Ute Pass Mini Warehouse Transportation Memorandum (LSC #184110) February 2, 2018

File No. PPR 18-028

RE: Ute Pass Mini Warehouse
El Paso County, CO
Transportation Memorandum
LSC #184110

1 SITE PLAN
SCALE: 1"=30'-0"

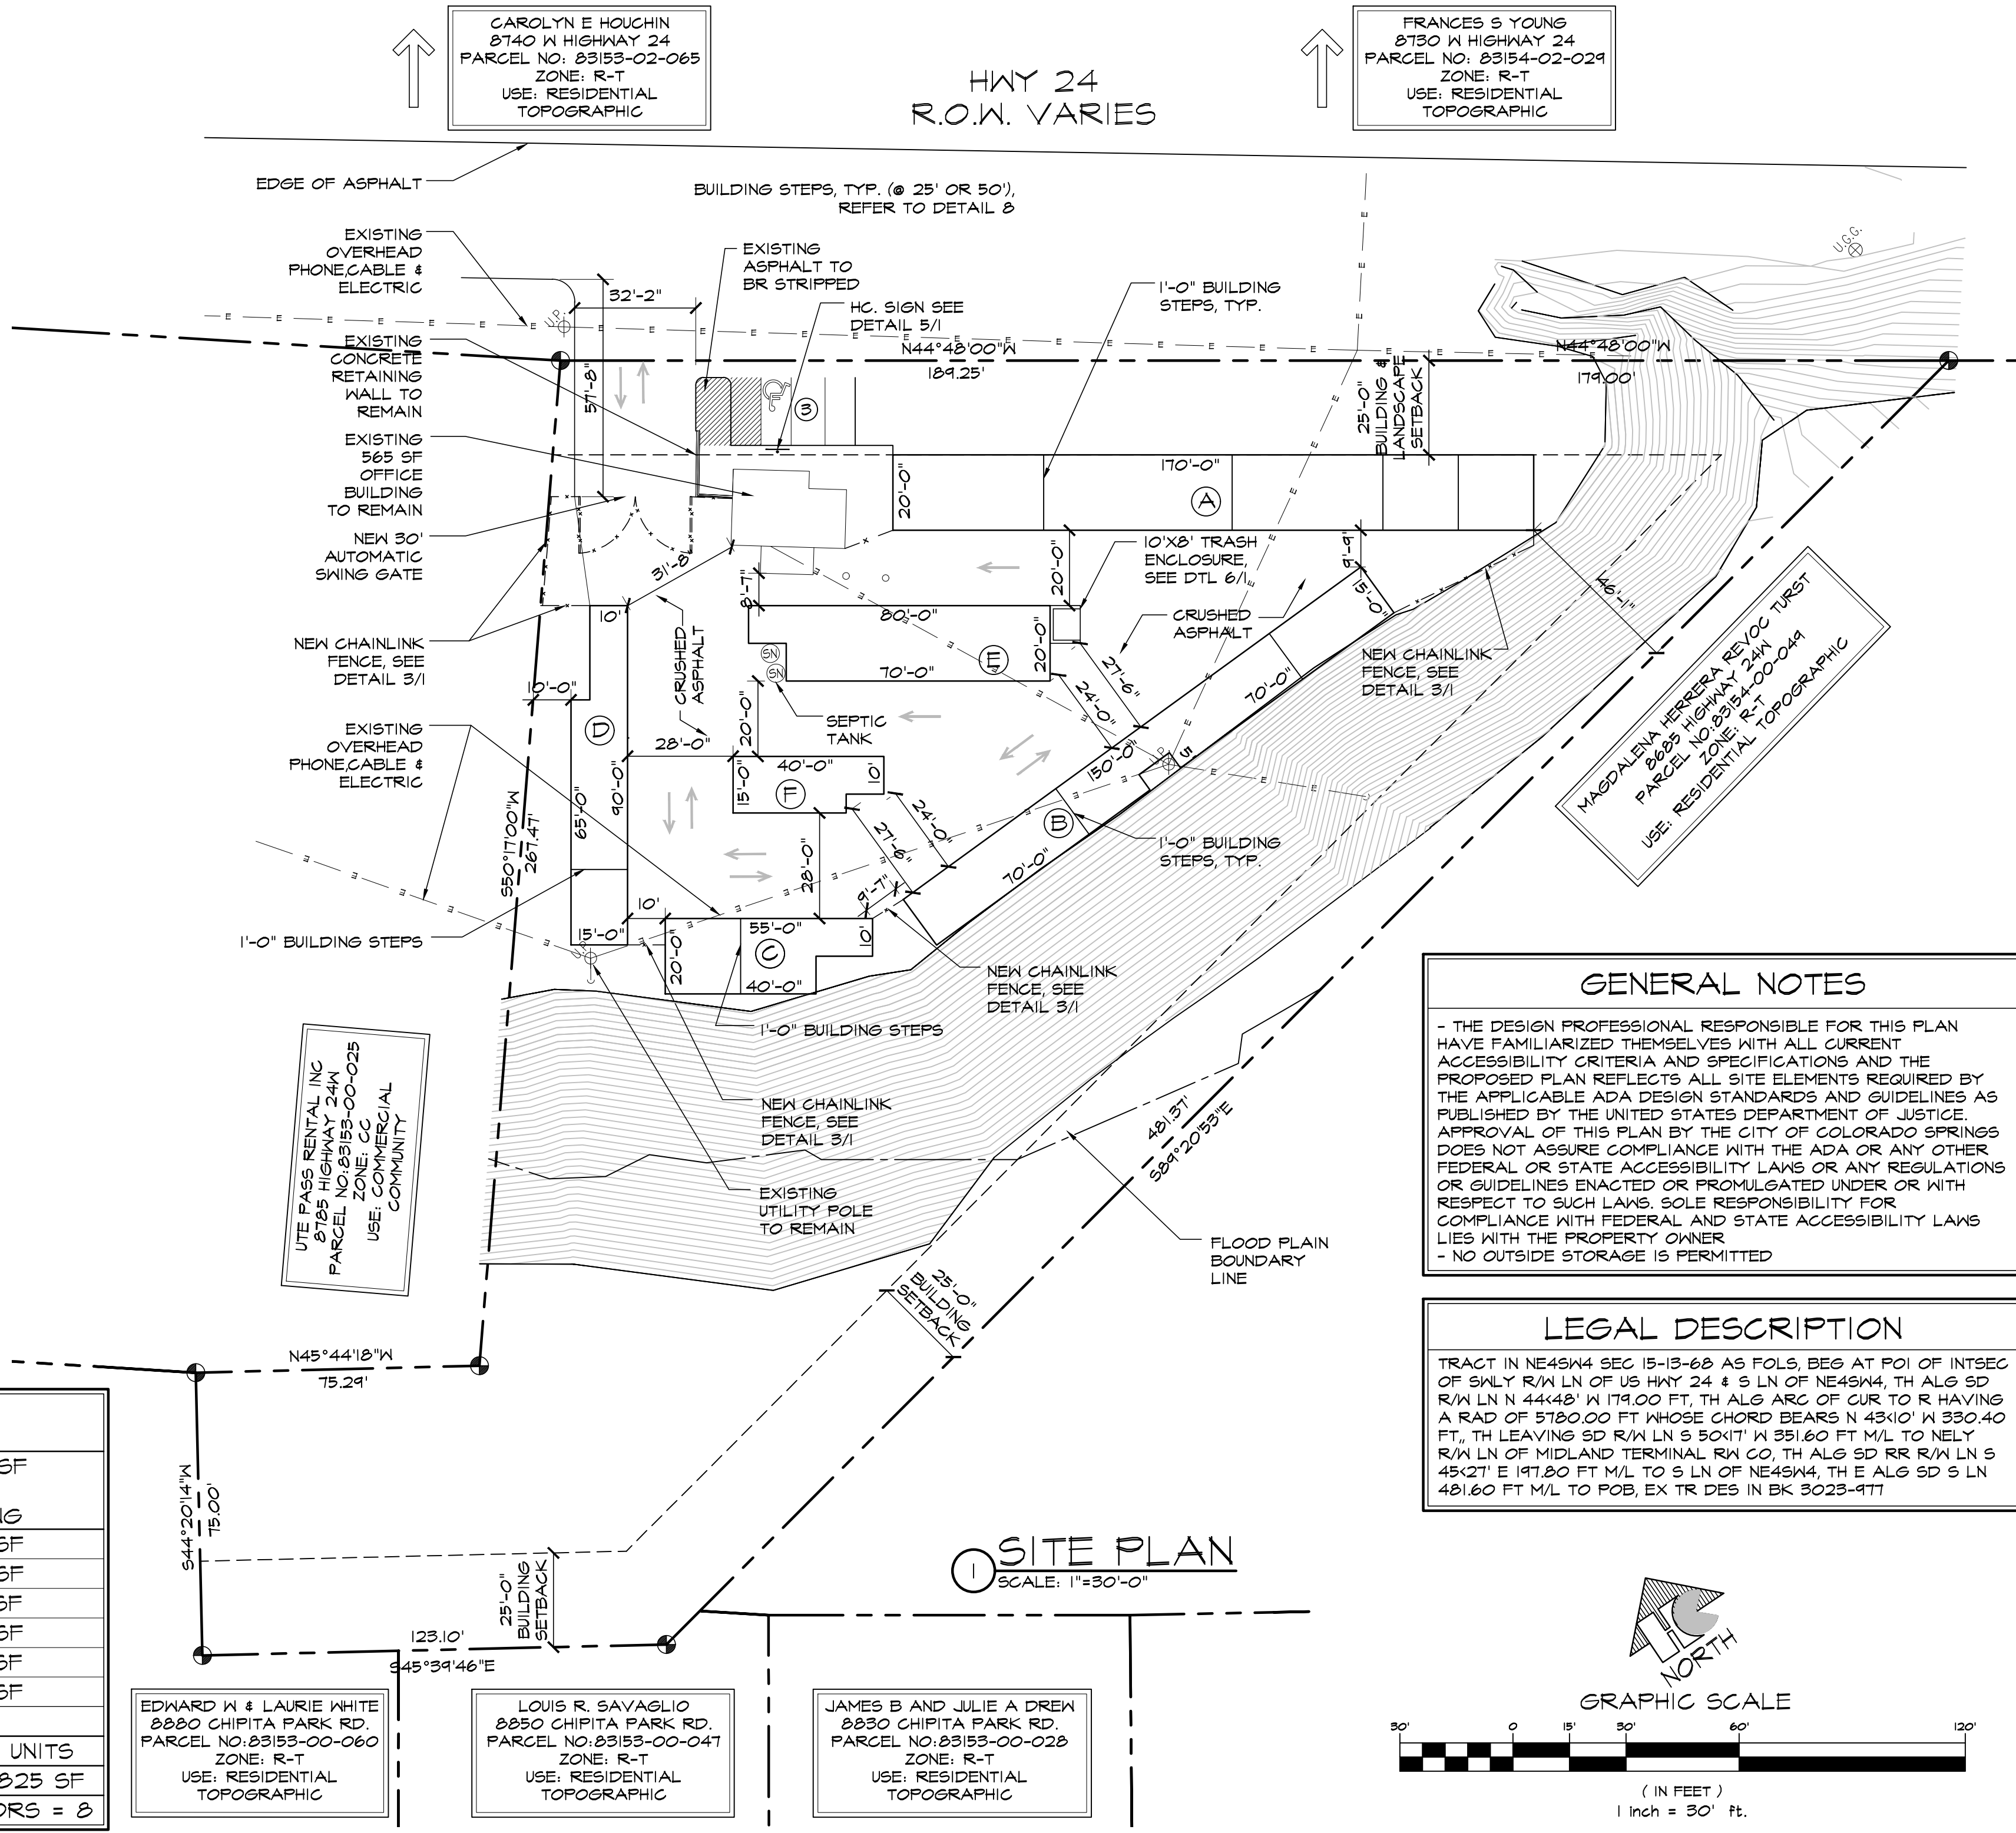
please add text discussing the proposed gate. (do you really want it opening outward? discuss required queue length.

there is curb and gutter in this section of Hwy 24 with distinct access points. this report should describe them, as well discuss the opening at the east end and how you intend to prevent or allow traffic to enter/exit at that location.
